# CITY OF ALBUQUERQUE

September 13, 2012

**Re: Juan Tabo Hills Unit 3A/3B Open Space Grading and Drainage Plan  
Engineer's Stamp dated 8-22-12 (M22/D017)**

TITLE: JUAN TABO HILLS UNIT 3B
OPEN SPACE GRADING & DRAINAGE PLAN

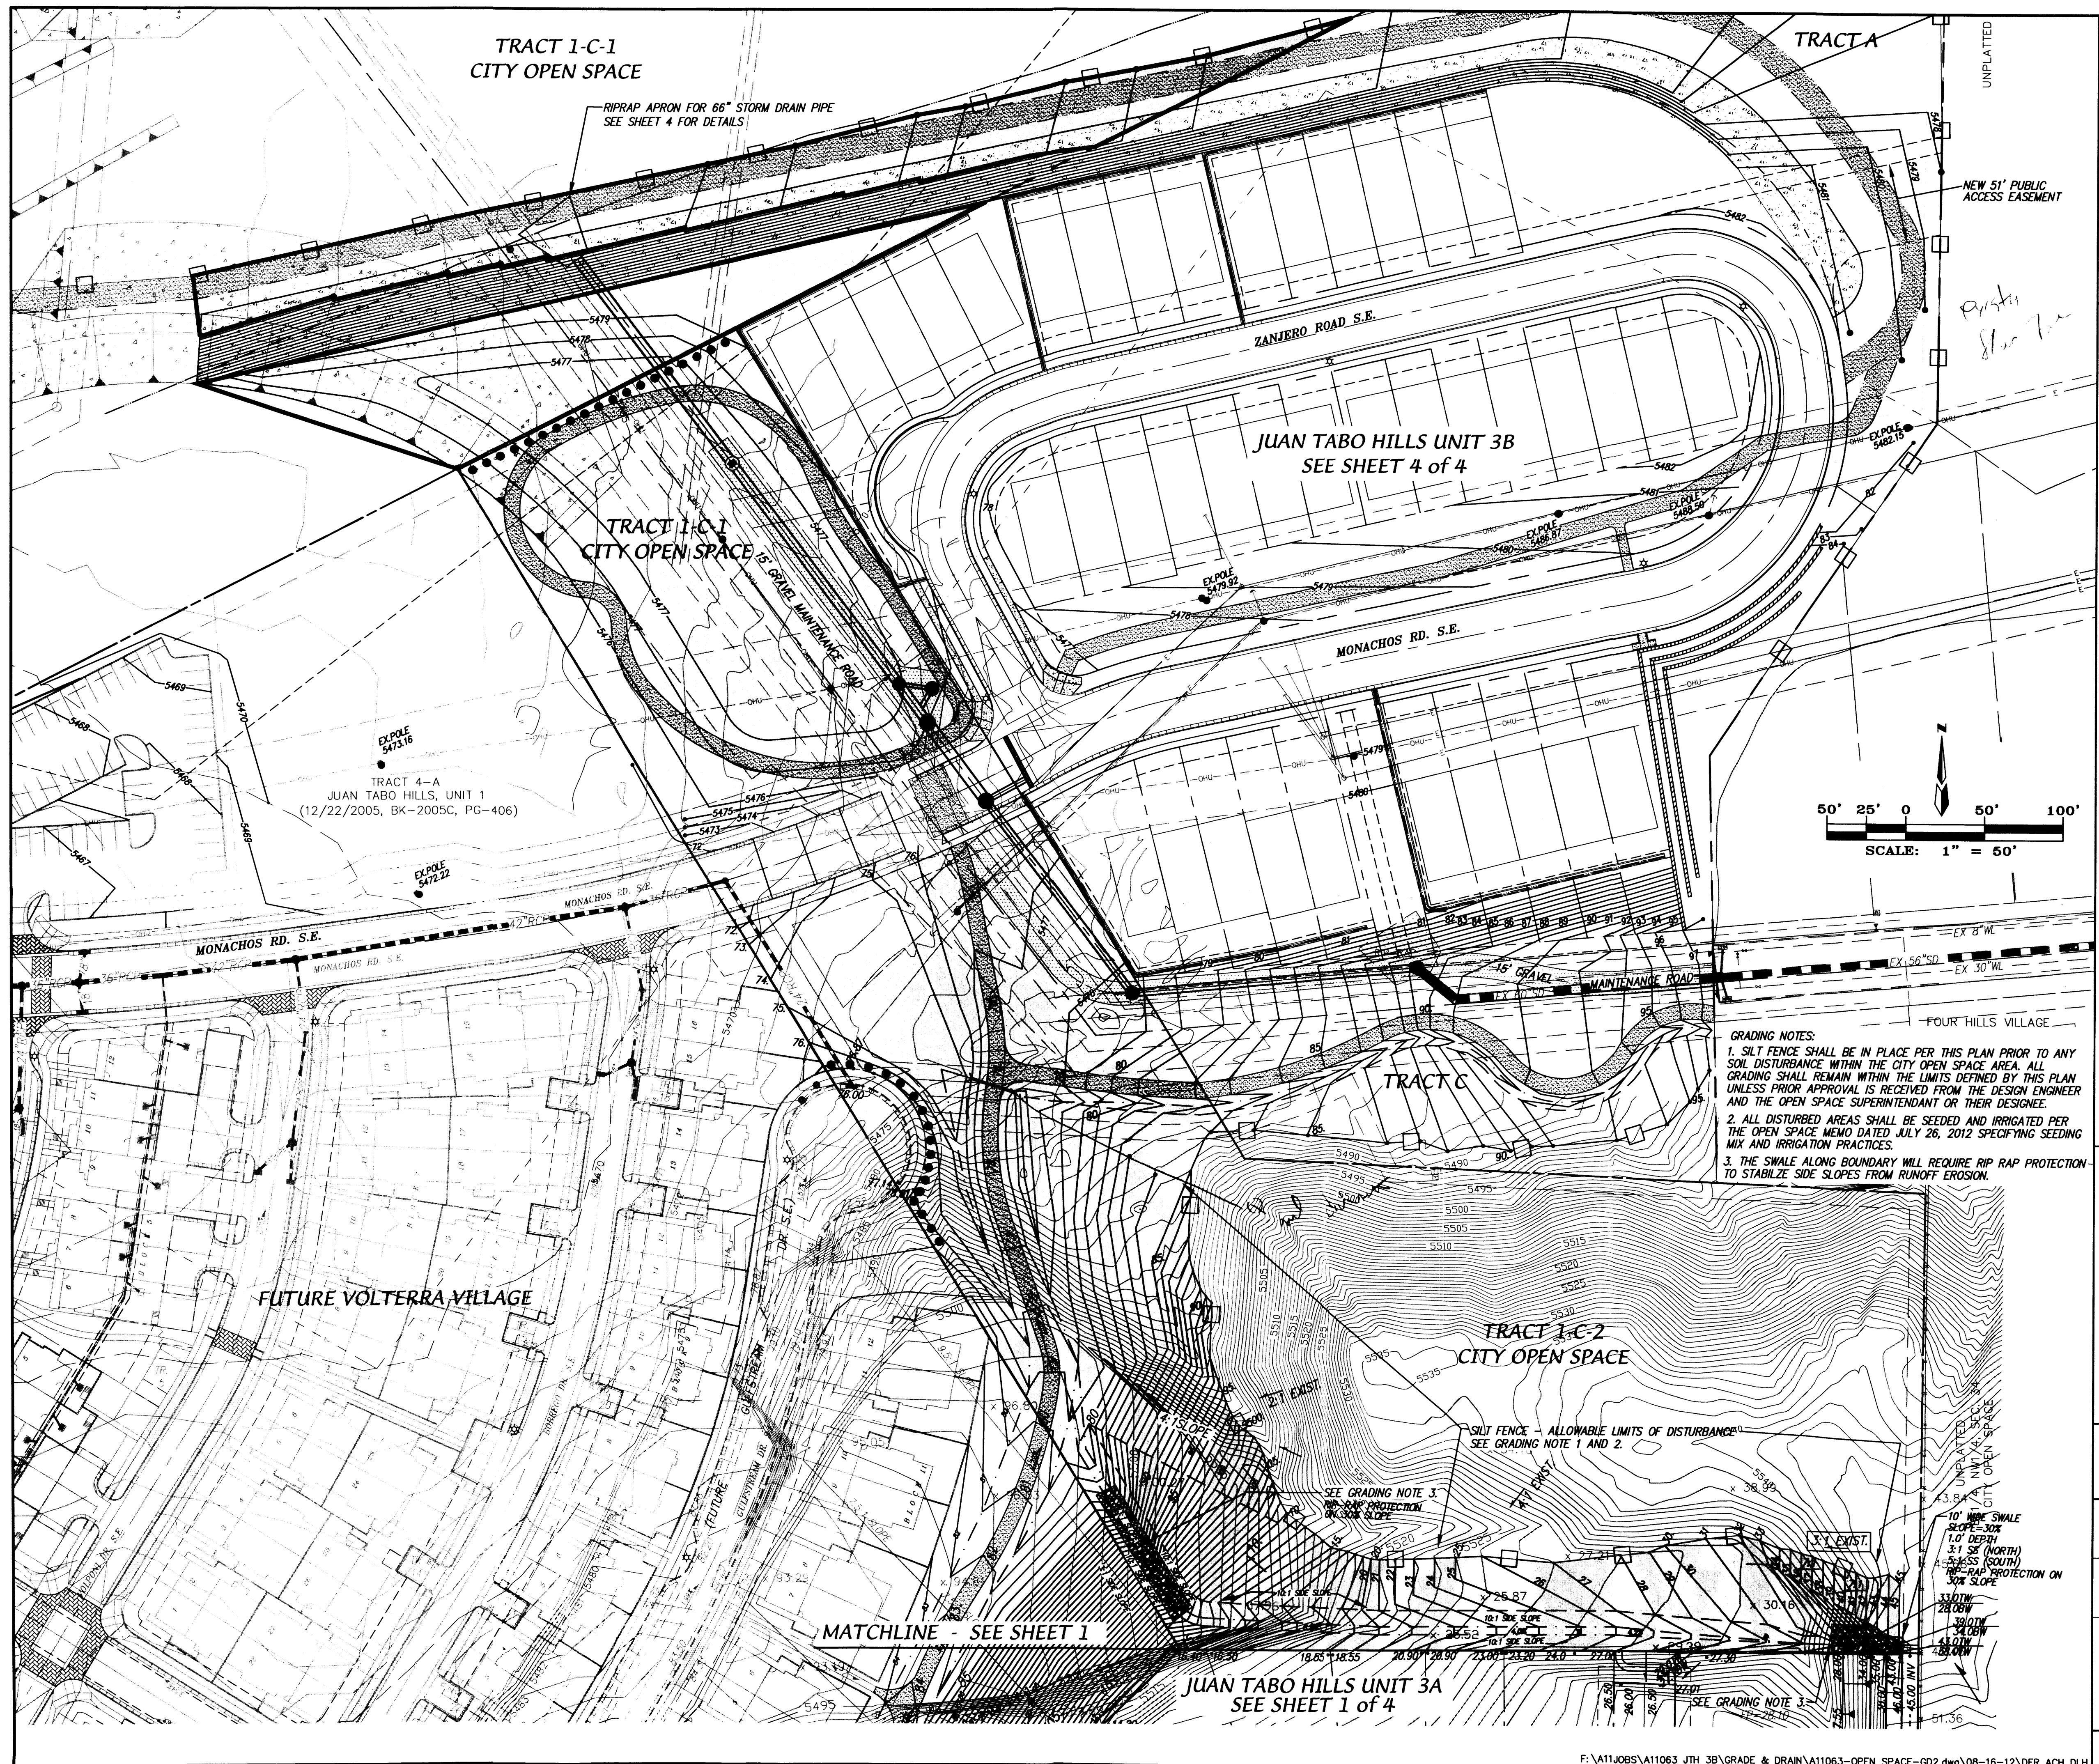
- Since this area is not detailed in the drainage report for Juan Tabo Hills Unit 3A, 3B or Volterra Village, most DPM requirements for a grading and drainage plan are applicable. Some are discussed below.
- Provide a flow for the culvert under the trail, with supporting calculations.
- Provide inverts and a size for the culvert.
- Show/discuss the current flood plain.
- A Floodplain Development Permit, through this office, will be required for any grading or construction in a floodplain.
- If you prefer, the drainage report for Juan Tabo Hills Unit 3A could be updated to include this area.
